Reference: 24168-RGB-ZZ-XX-CO-ST-0003-SJ: DA 250804

Adam Marshall  
Thirdi Crows Nest Residential Developments  
53 Hume Street  
CROWS NEST NSW 2065

**RE: STRUCTURAL DESIGN CHANGE – CAR PARK WALLS PUSHED OUT FROM PREVIOUS SSSA LAYOUT**

Sheet title  
CARPARK LEVEL 05

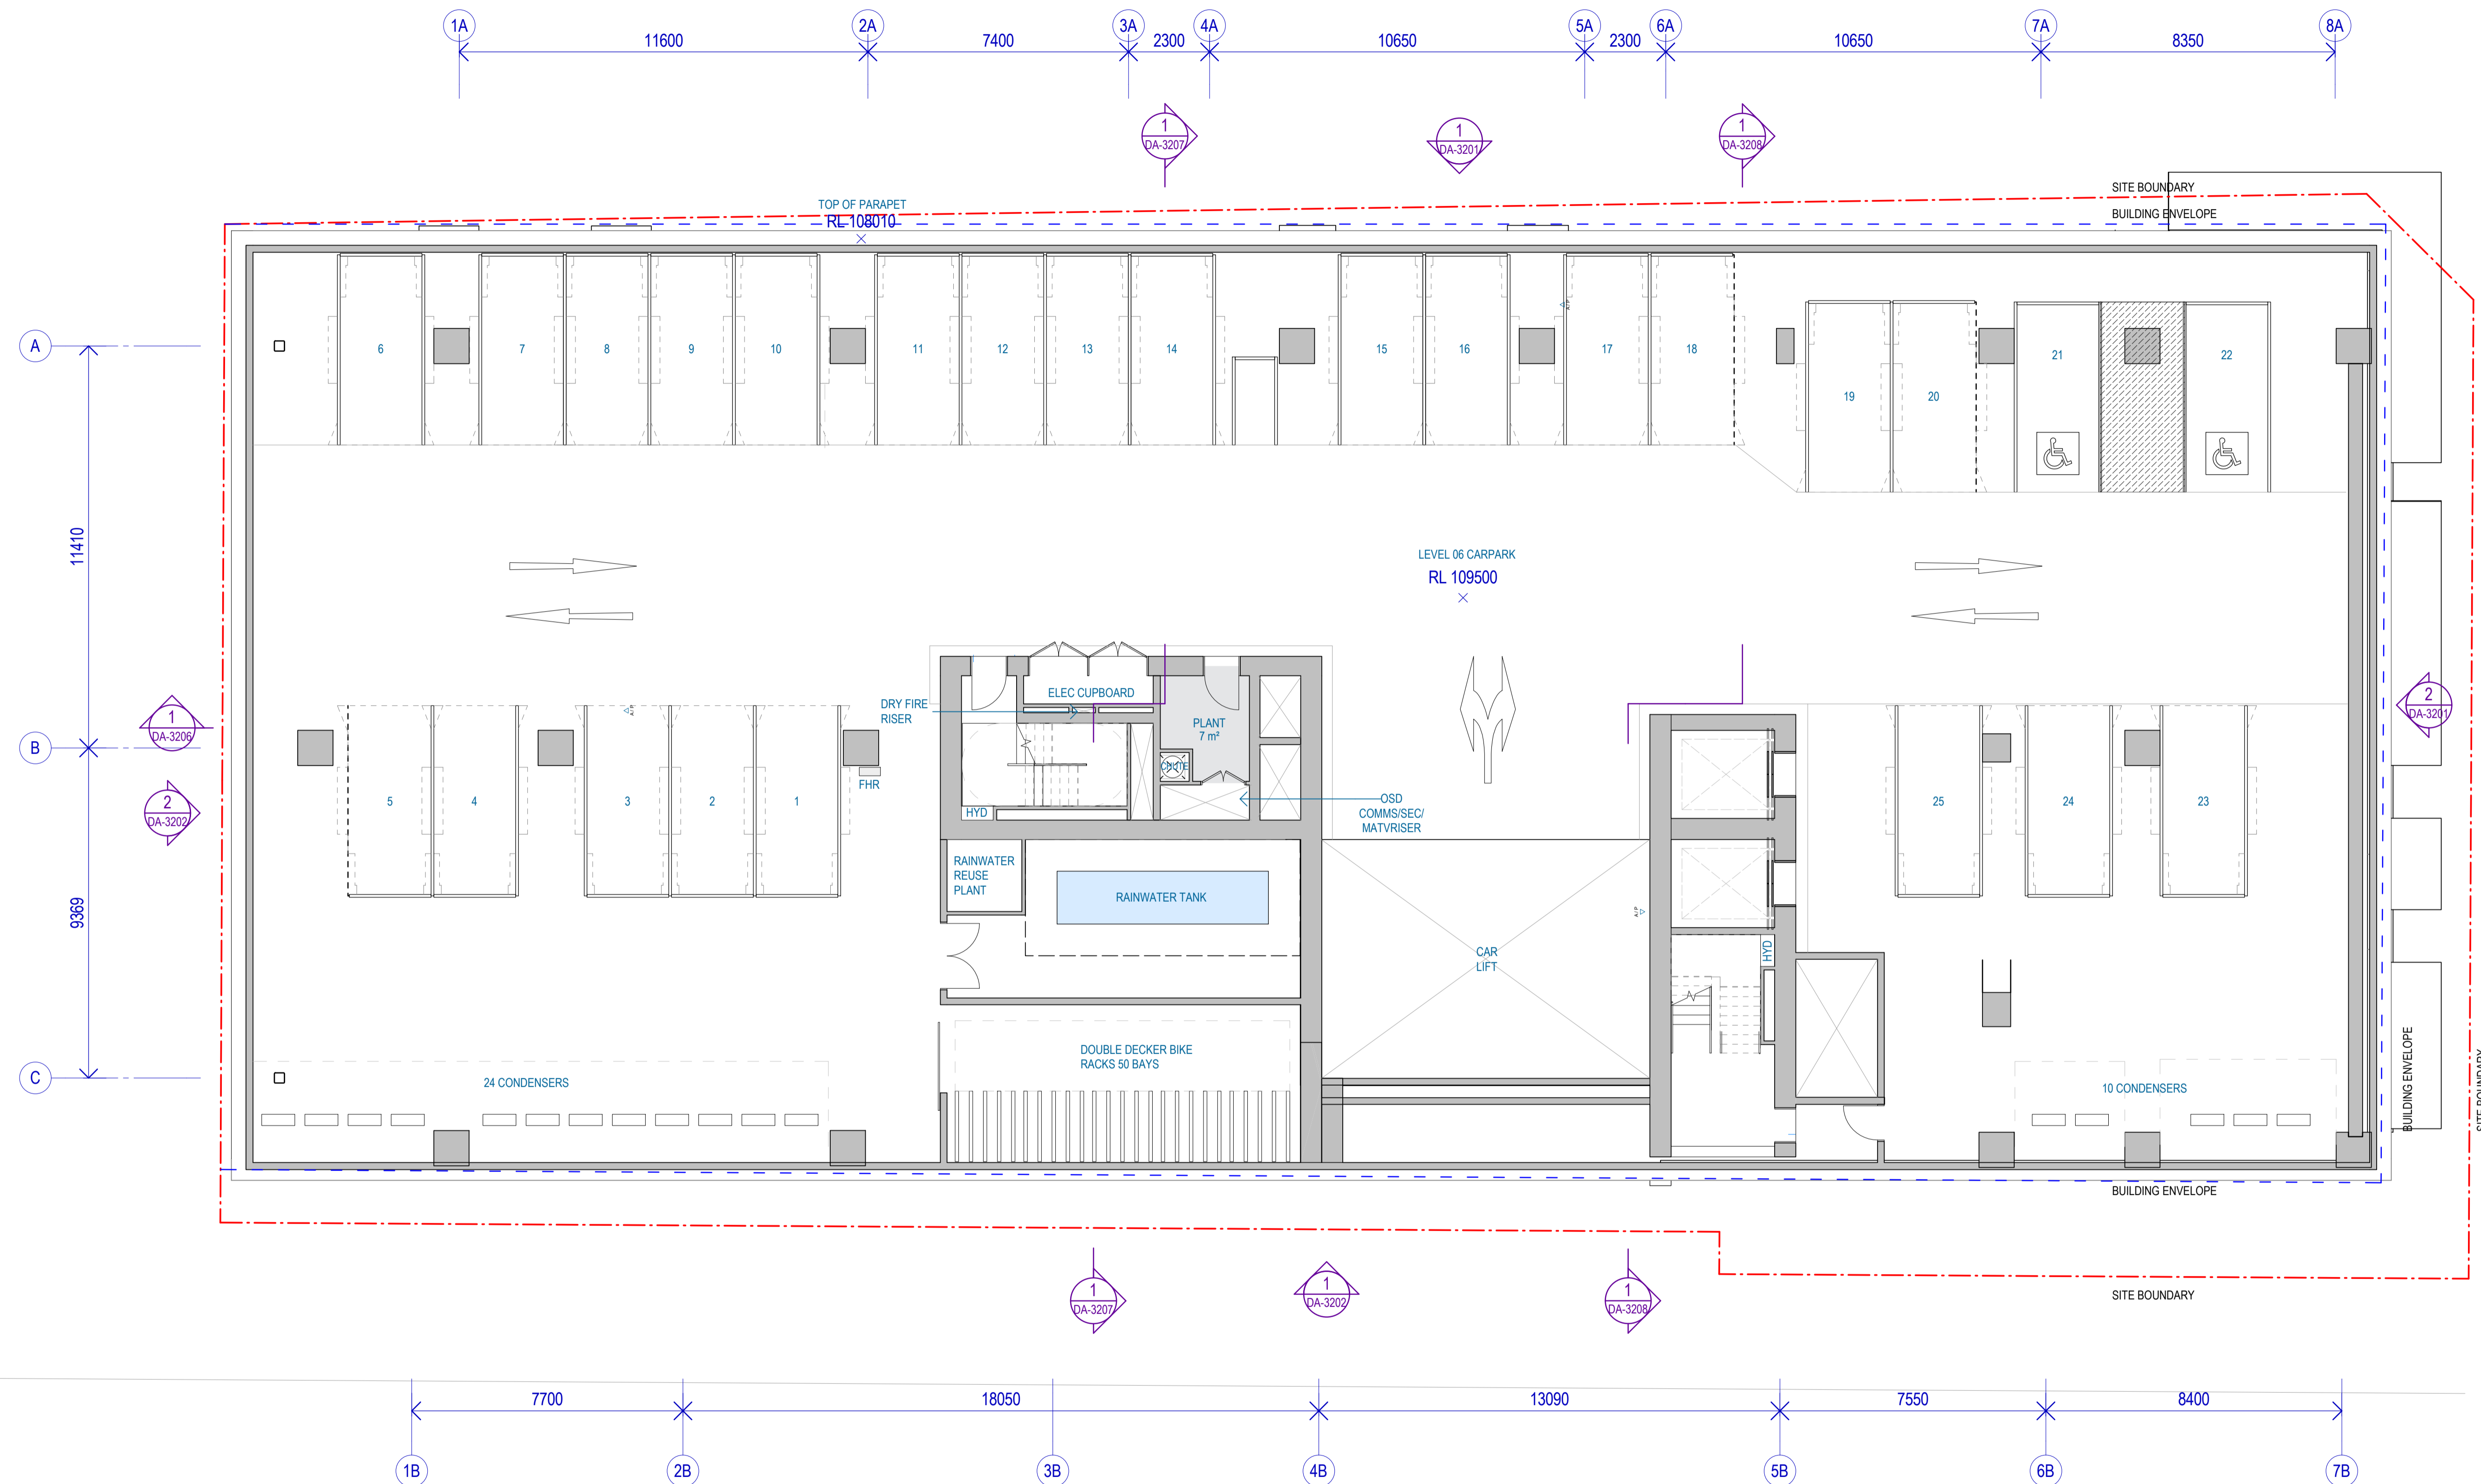
- Perimeter car park walls have been moved outward from the originally approved SSSA layout (Fig. 1 → Fig.2 and Fig.3 → Fig.4), in order to align with the newly added perimeter columns and transfer wall intended to support the Level 08 transfer structure.

- With the carpark wall relocation, new perimeter columns now directly support loads from the underside of the Level 08 transfer slab and beams.
- Without extending the columns on the perimeter wall vertically, there would be discontinuities in the load path, resulting in unsupported cantilevers and inefficient load transfer.
- Extending columns upward restores continuity, ensuring loads from Level 08 are effectively transmitted down through the structural system to the foundation.

- A transfer wall has been provided along the Hume St side of the carpark to support loads from the Level 08 transfer slab and beams. The 400 thick transfer wall will extend down from Level 07 to Level 05.
- Similarly, without providing this transfer wall on Hume St, there would be discontinuities in the load path. Providing this transfer wall restores continuity, ensuring loads from Level 08 are effectively transmitted down through the structural system to the foundation.

- The originally proposed landscape buffer along the perimeter will need to be revised as it conflicts with the repositioned column layout and provision of the transfer wall.
- Keeping the landscaped zone as per the original SSDA would impede proper placement of structural columns and the transfer wall and could compromise the support of the transfer slab.
- Consequently, the landscaping zones must be reduced to maintain structural integrity and compliance with relevant building standards.
- The originally proposed landscape buffer along Hume St is no longer feasible due to the provision of the transfer wall in the same location.

- With support from RPS, a portion of the landscaping areas can be reintroduced around the Level 05 carpark (not along Hume St) as per Figure 5 by allowing maintenance of the gardens through an access point from the carpark façade. A rope system may be required for the maintenance of the gardens along Pacific Highway. This is aimed to help compensate for the loss of landscaping zones due to the structural changes.
